Littlehampton Marina
Ferry Road
Littlehampton
West Sussex
BN17 5DS

Our Ref: LU/32/20/PL

**Town & Country Planning Act 1990 (as amended)
Town and Country Planning (Development Management Procedure) (England) Order 2015
Application for Full Planning Permission**

Development Retention of detached marina workshop.
Location Littlehampton Marina Ferry Road Littlehampton

Drawing No. 131087/10

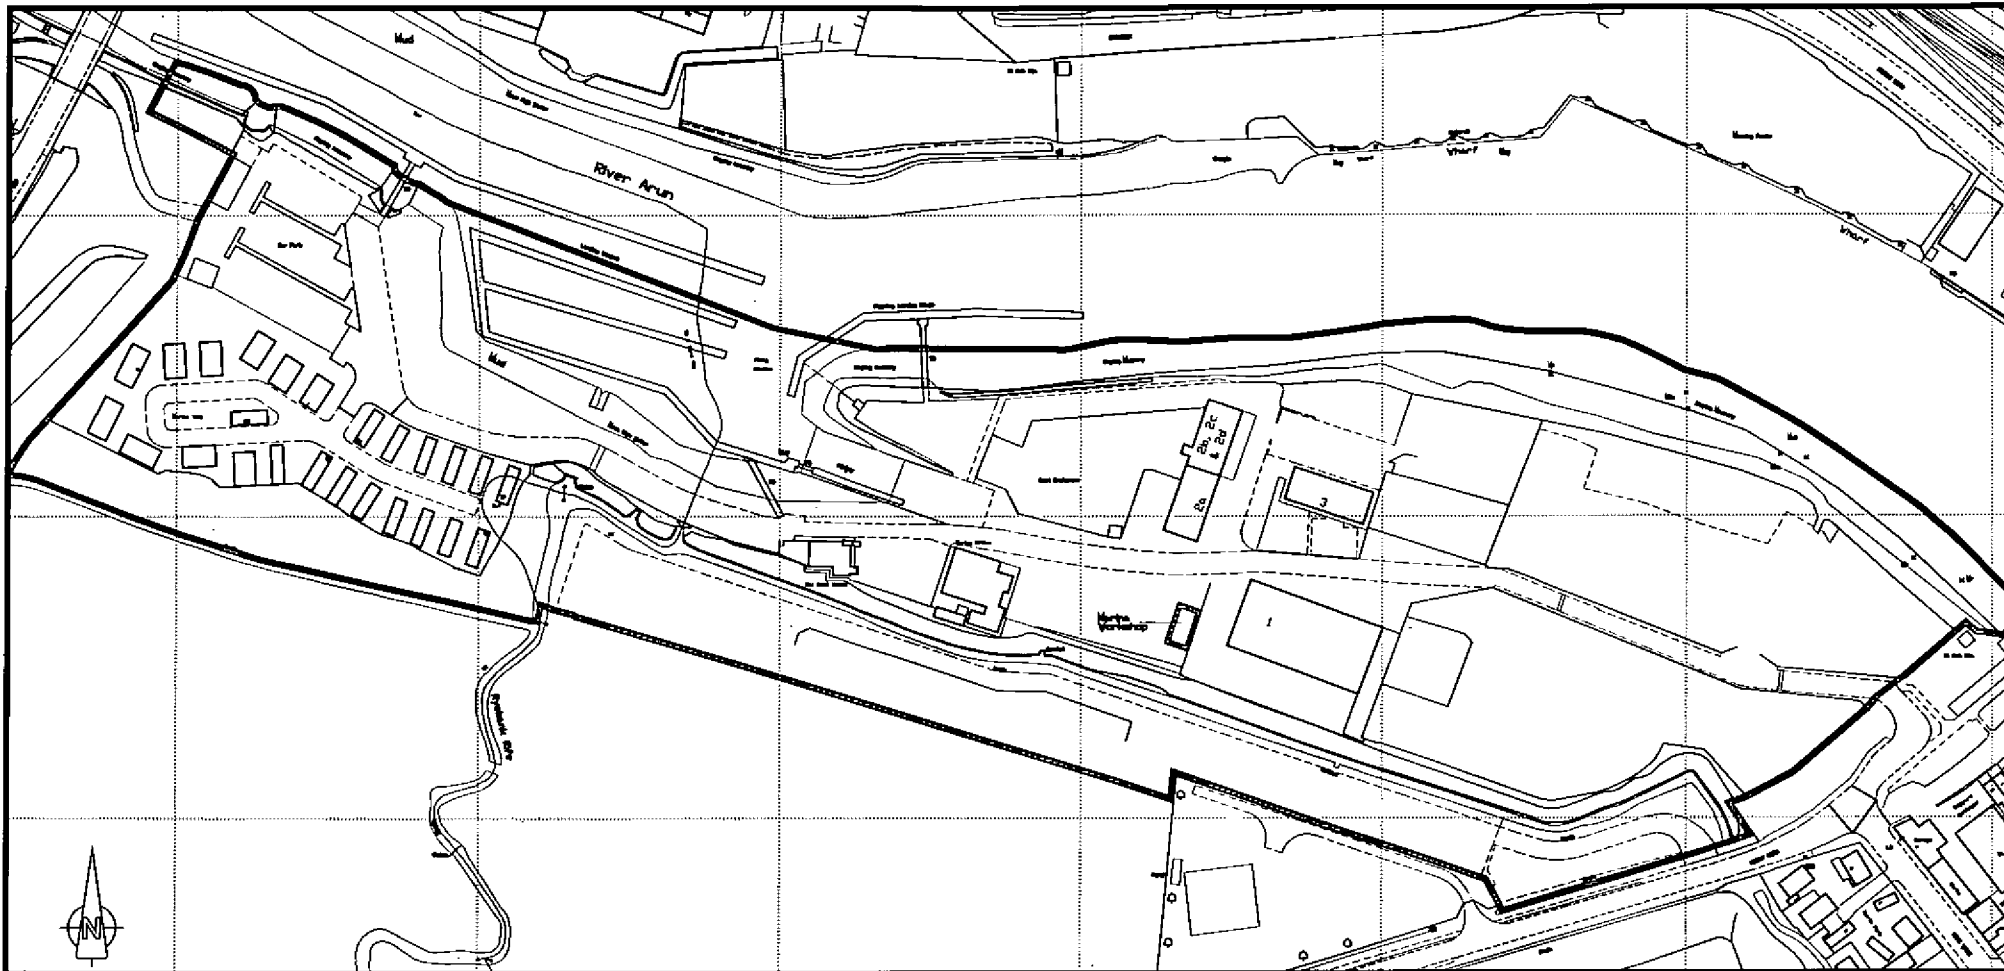
Location Plan

Please submit an amended Location Plan showing the red edge for the proposed site area. For clarity, please remove the bold boundary line.

BLOCK PLAN SCALE 1:500

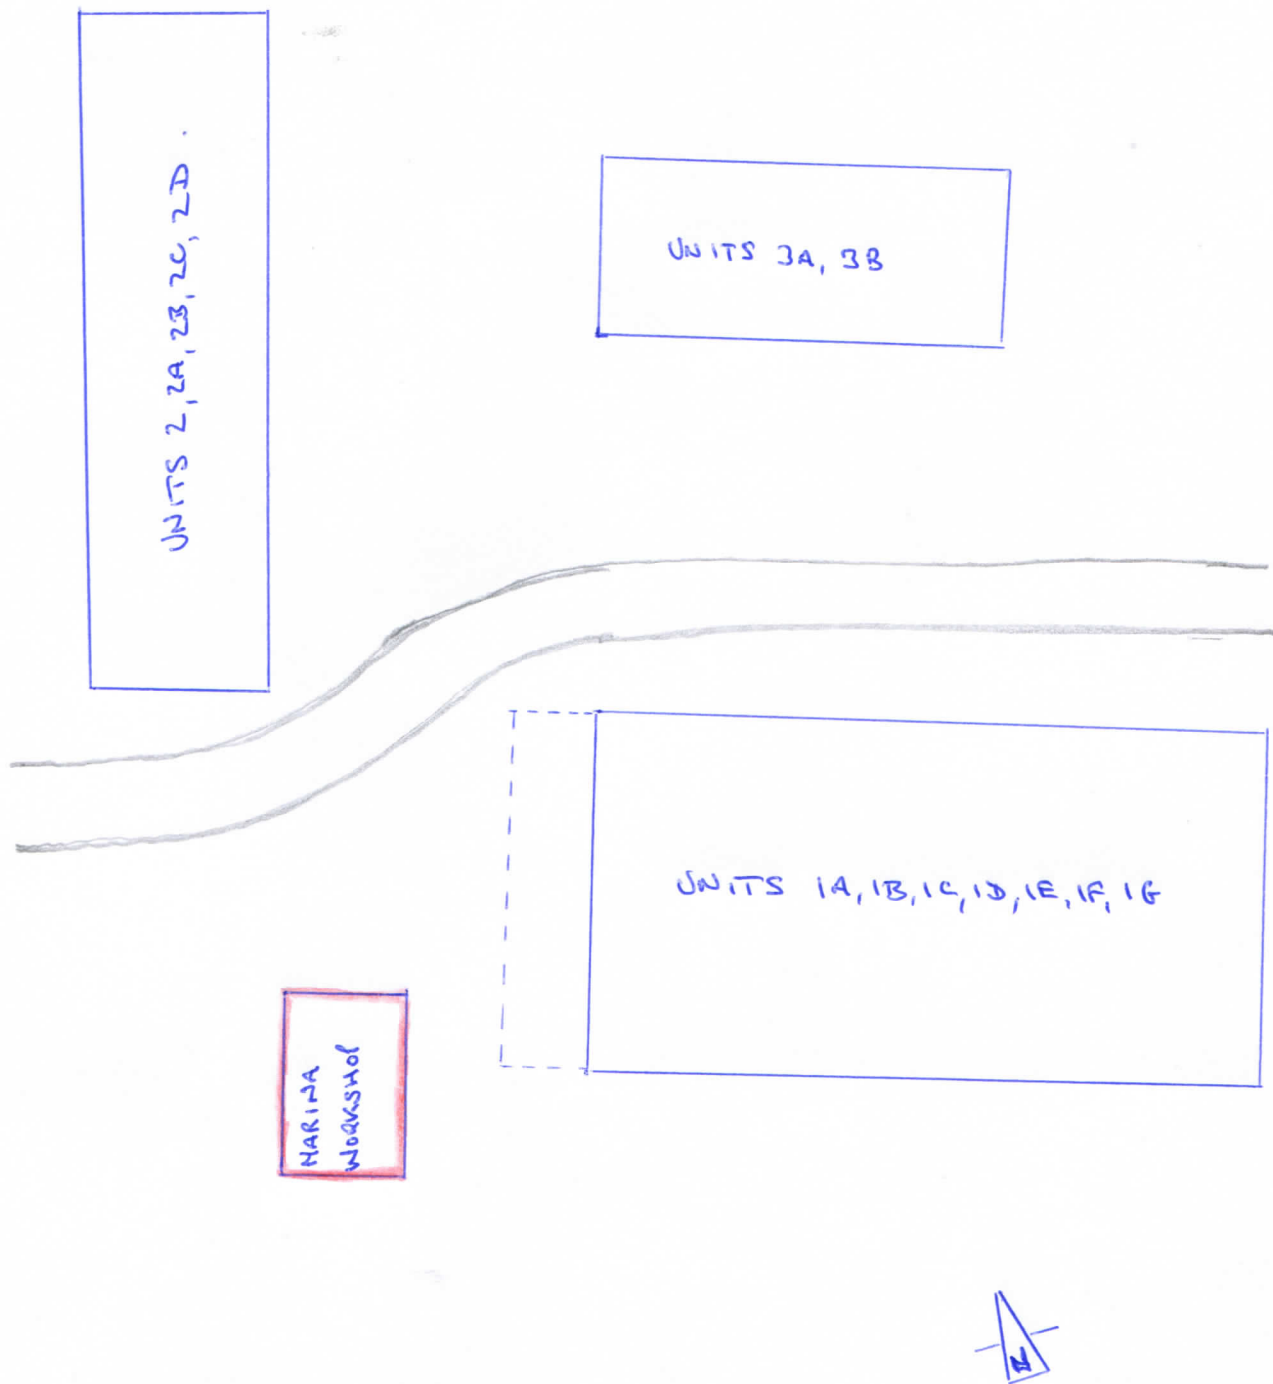
Block Plan

Please submit 1 electronic or 3 paper copies of a block plan at a scale of 1:500. Further details of what must be included on the plan can be found in the Validation Requirements List.
